Please ask for: Nicola Moore
Email: nicola.moore@arun.gov.uk
Telephone: Ext 37944
Our Ref: AL/128/21/CLP
Your Ref:
Date: 11th November 2021

Lawful Development Certificate for a Proposed Use or Development

Development: Single storey extension and Loft Conversion
Location: Nyton Road Westergate PO20 3UQ

Drawing title
SITE AND OUTBUILDING PERMITTED DEVELOPMENT

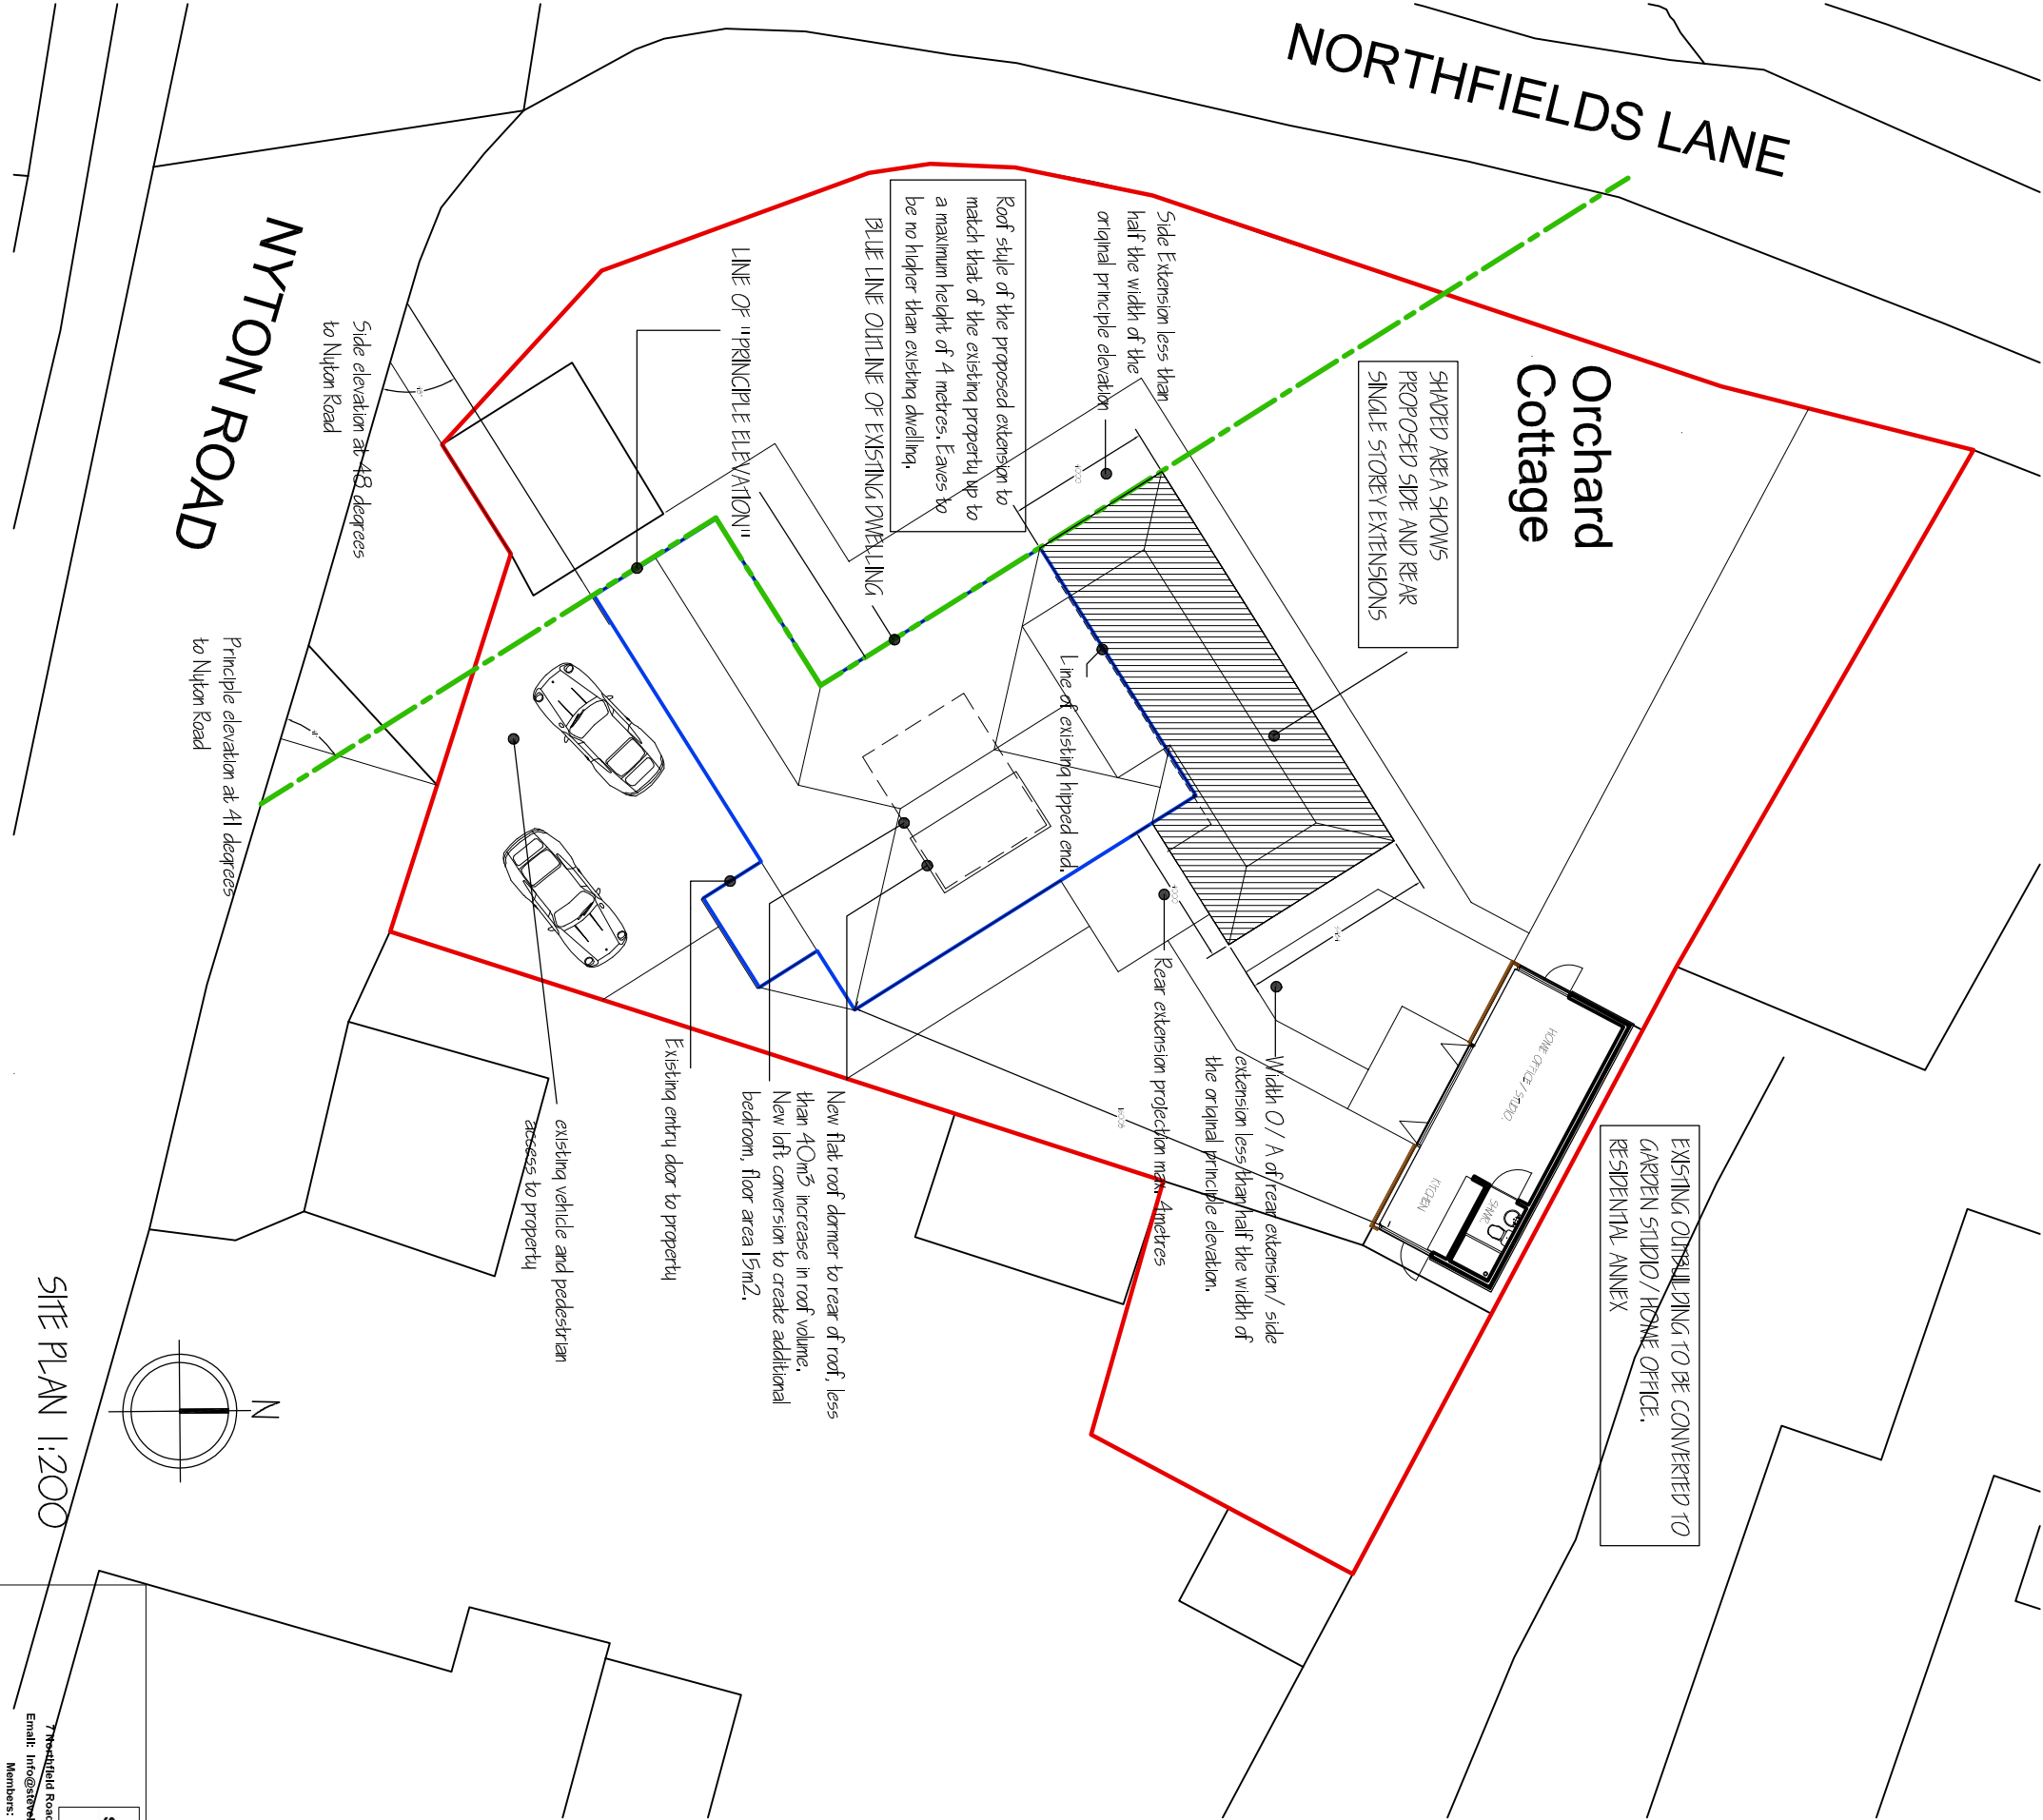
The submitted Proposed Floor Plan appears to show the First Floor layout. Please submit floor plans clearly labelled as Ground/First Floor.
